Re: Tract N-1-B Watershed Subdivison - Sketch Plat Submittal

TRACTS N-1-B, WATERSHED SUBDIVISION zoned **PC**, located on **ARROYO VISTA** between **118TH ST** and **98TH ST** containing approximately 60.08 acre(s). (J-8)

Development Facilitation Team (DFT) – Review Comments

DRB Project Number: 2024-010571
Arroyo Vista – Watershed Subdivision

PRELIMINARY PLAT  
SAVIO RIDGE  
SUBDIVISION  
(REPLAT OF TRACT N-1-A & N-1-B  
WATERSHED SUBDIVISION)  
CITY OF ALBUQUERQUE  
BERNALILLO COUNTY, NEW MEXICO  
DECEMBER, 2024

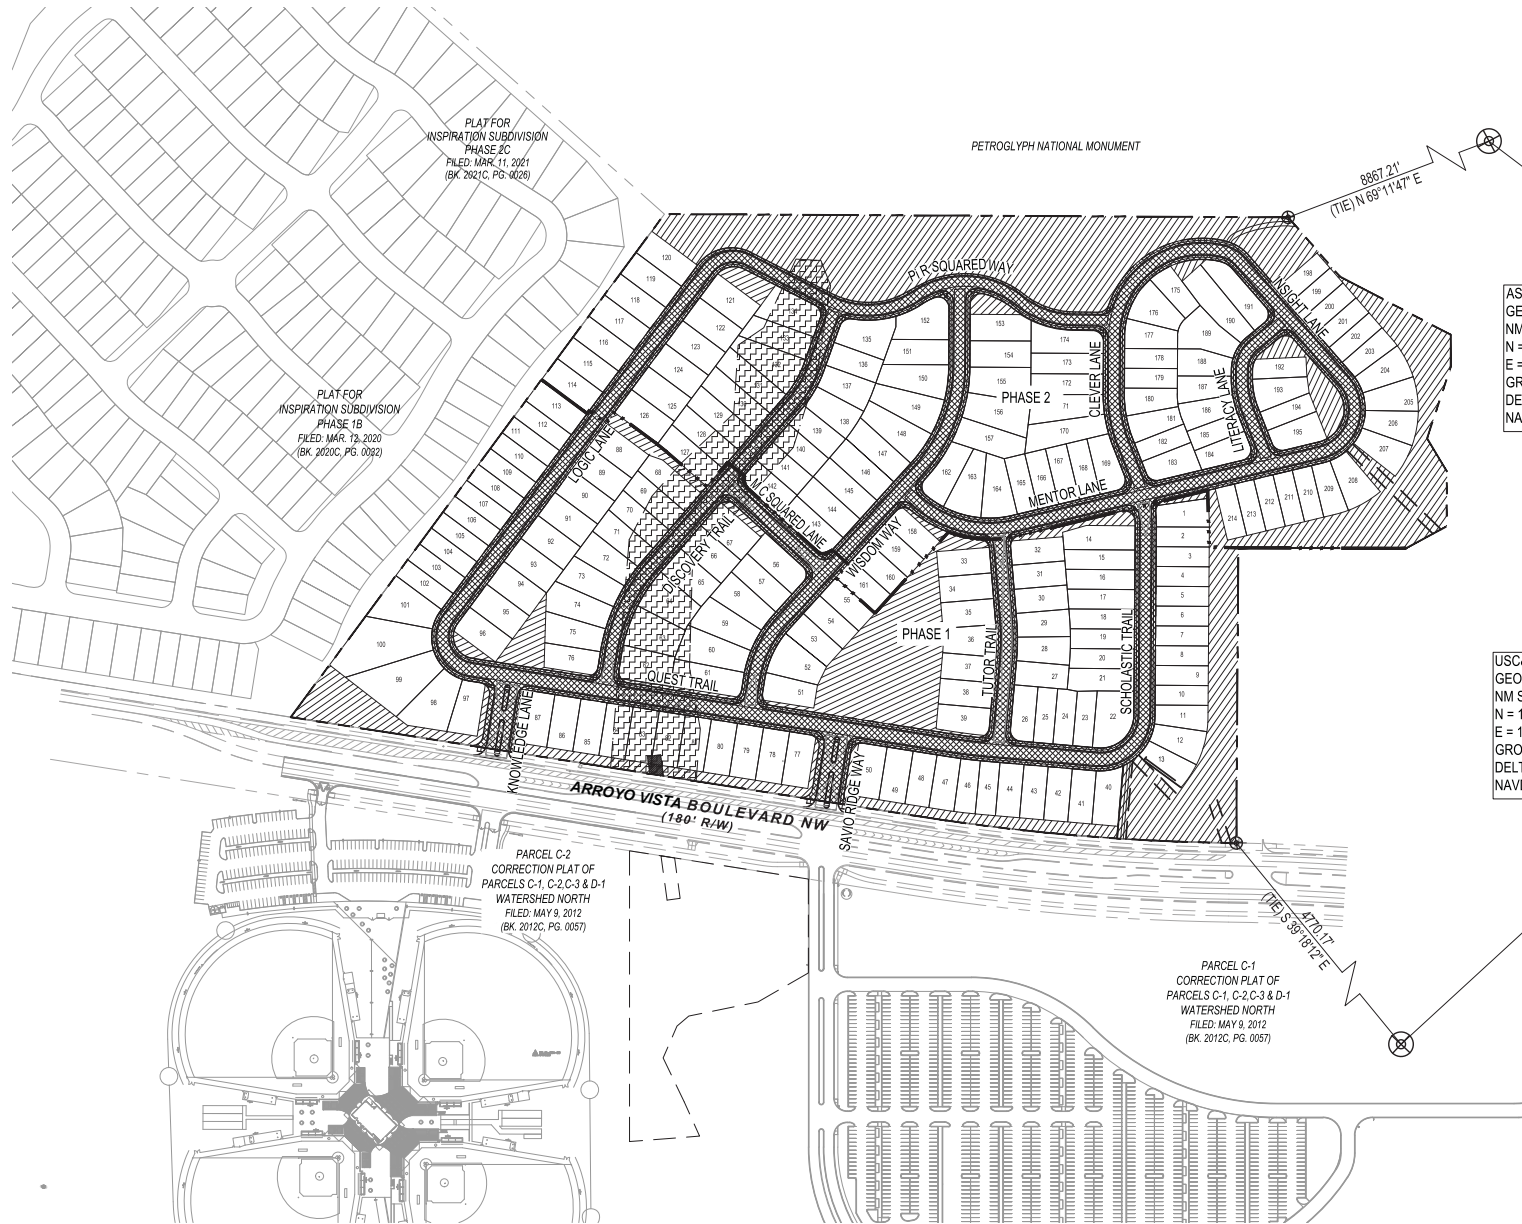
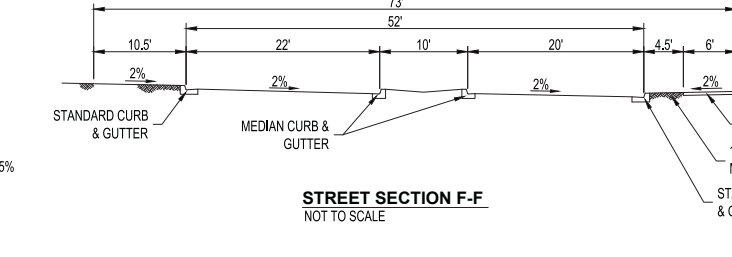
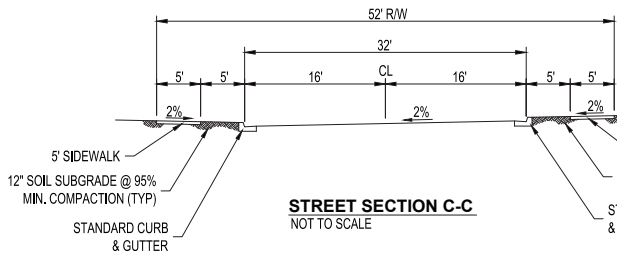
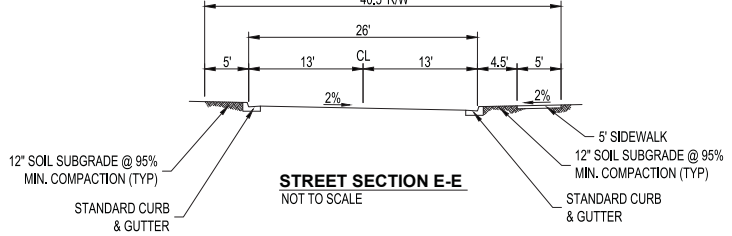
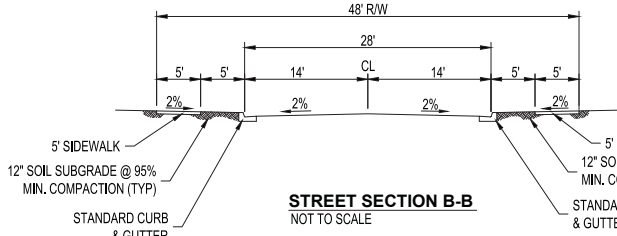
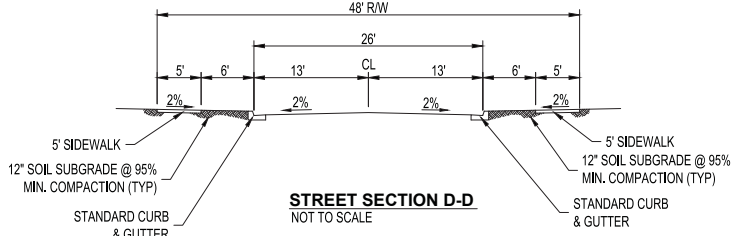
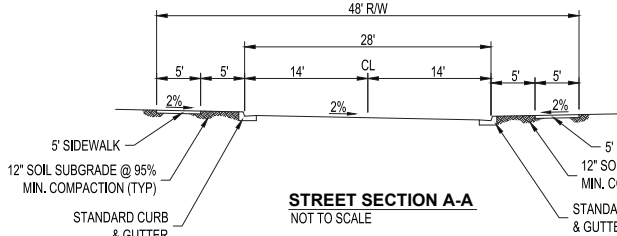
It would appear that you have been able to keep some block lengths under 600 feet, but some are not.
